From: Jordan Bovee <jordan.bovee.hsy@colvilletribes.com>
Sent: Thursday, November 20, 2025 12:36 PM
To: Ellie Myers
Cc: Guy Moura; SEPA@dahp.wa.gov
Subject: Re: SX-25-00019 Rayner East Shoreline Exemption - Notice of Application
Attachments: CCT Trad. Terr. 2025.pdf

In response to the SX-25-00019 Rayner East Shoreline Exemption NOA -

You are receiving this request for shoreline review with an associated 15-day comment period because this application **SX-25-00019 Rayner East** is proposing a project (600 square foot garage) within shoreline jurisdiction that is not exempt from cultural resources review pursuant to Kittitas County SMP 5.1(B)(1)(a). In accordance with the settlement agreement between the Yakama Nation and Kittitas County, Kittitas County Resolution No. 2018-195 and the Department of Ecology Final Approval (letter dated 1/14/19, effective 1/28/19) of the County's amended Shoreline Master Program, Kittitas County is hereby requesting comments regarding the proposed project.

Drawing file: Sx-25-00019 Rayner East / SX-25-00019 Rayner East - Application - Site Plan.pdf

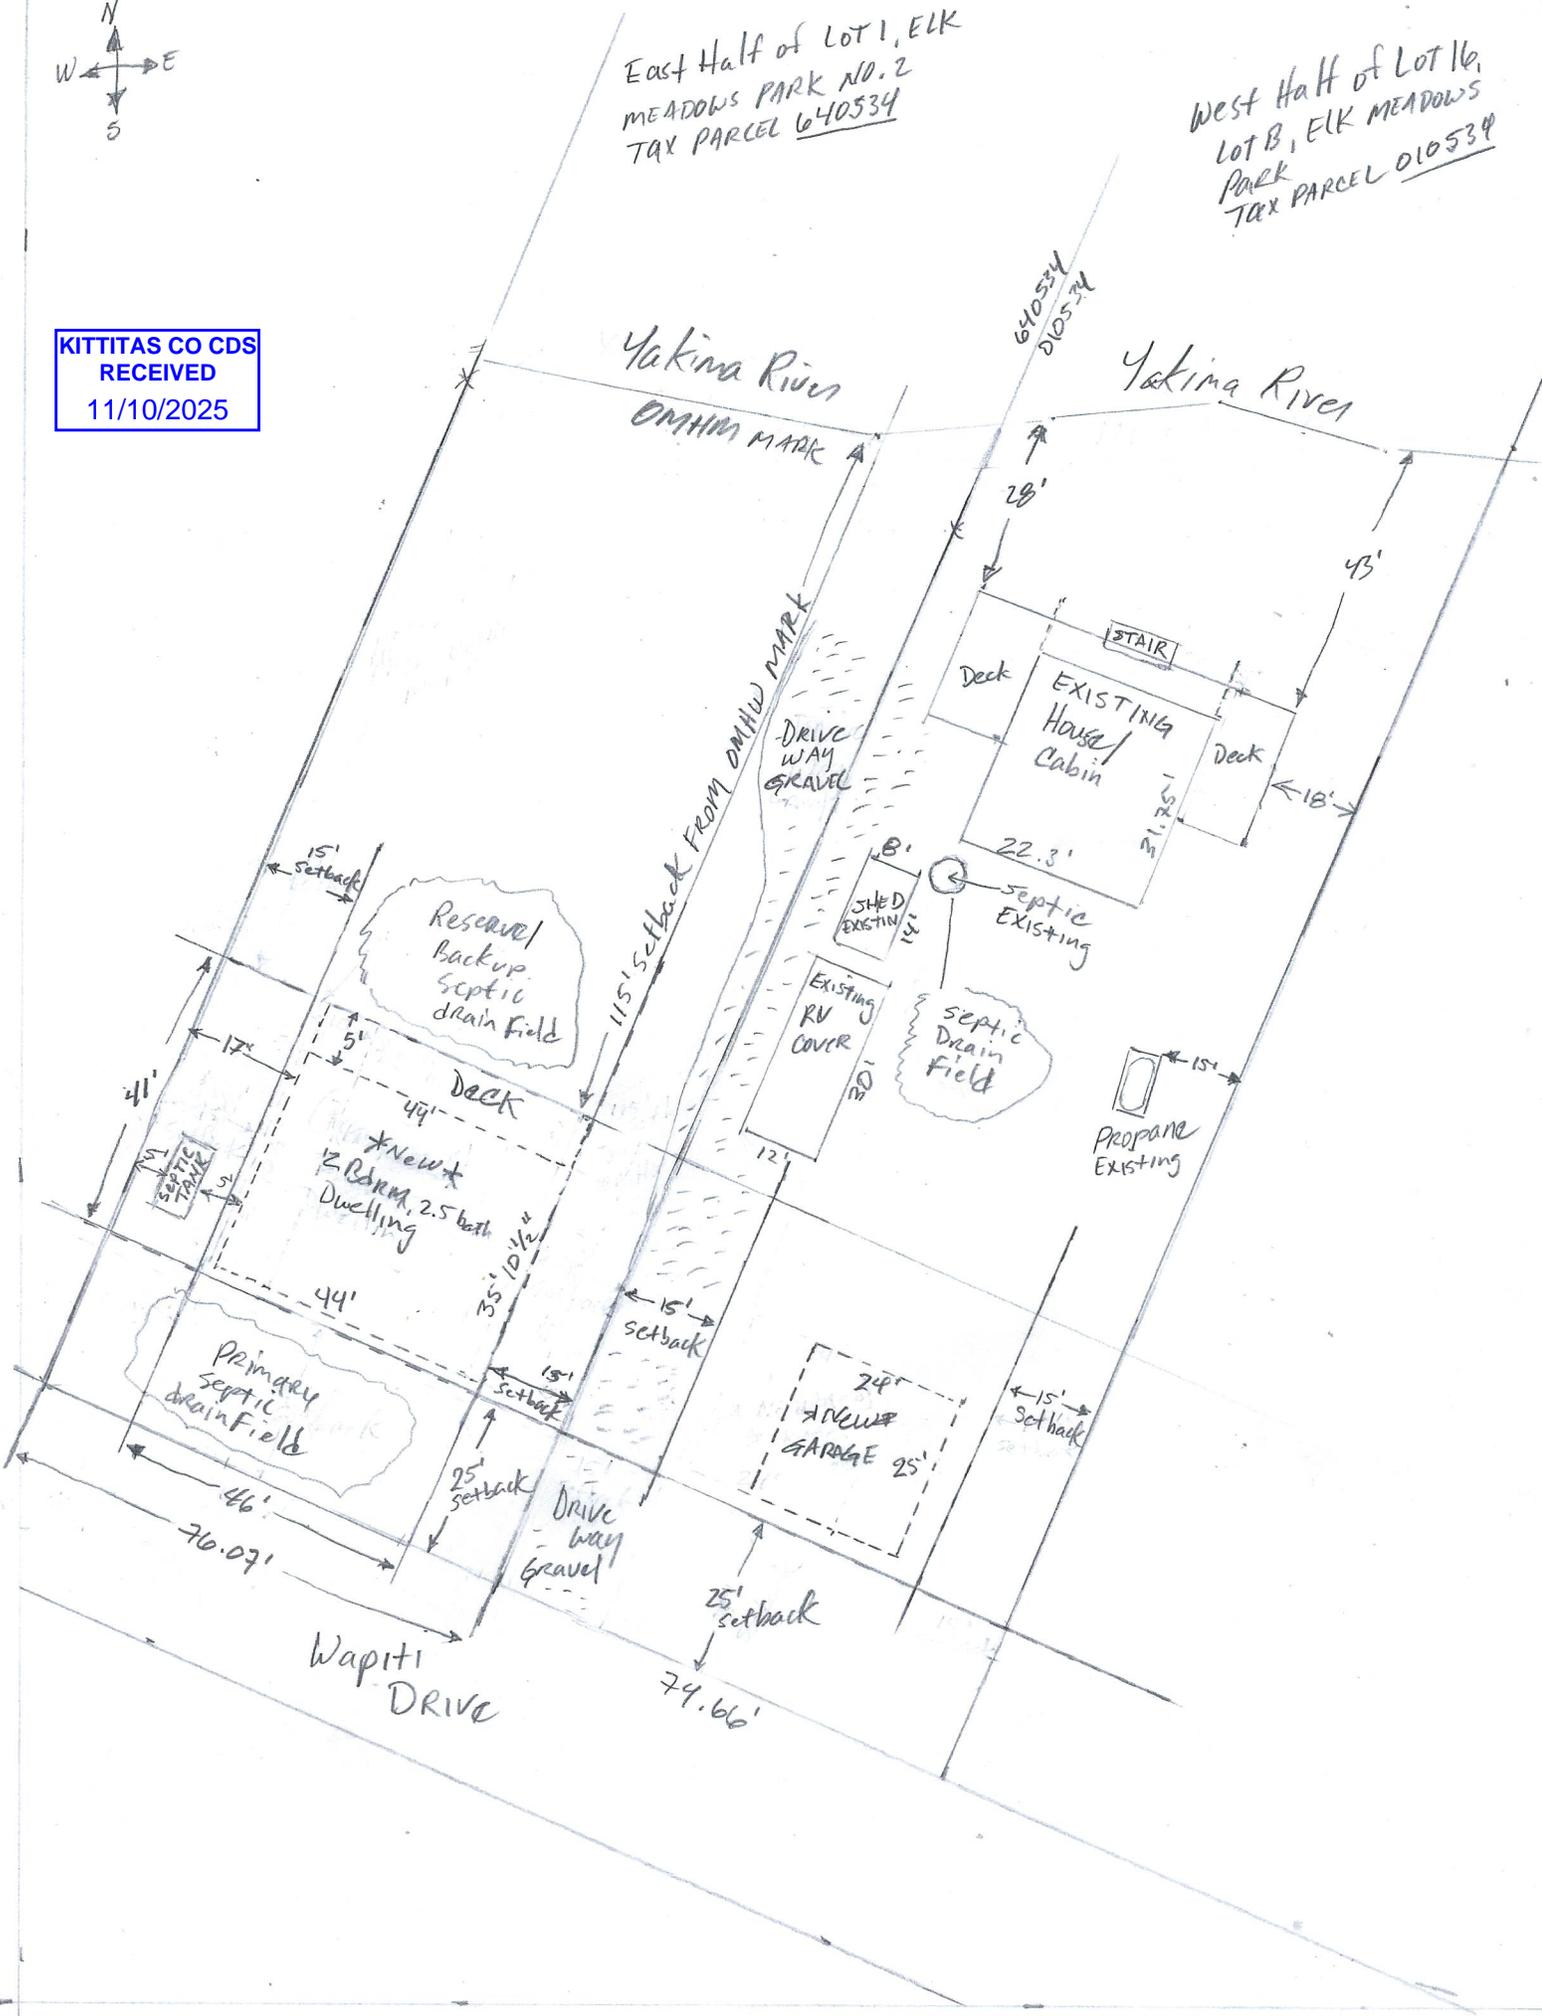
Based on our review of the proposed undertaking against State and Tribal sensitivity maps, we would like to note that the project does fall within an area considered by DAHP's risk assessment model to be at high risk for cultural resources to be present. That there are few known occurrences of pre-contact or historic sites in the immediate vicinity may be due to the lack of cultural resources survey more than anything else.

Given the relatively small footprint of the proposed garage, we recommend only that the proponent have on hand an Inadvertent Discovery Plan (IDP) during any ground disturbing activities as a measure of precaution, and request that the CTCR be notified should any cultural material be disturbed during the course of the construction. Washington's Department of Ecology has a useful template that the project proponent could use.
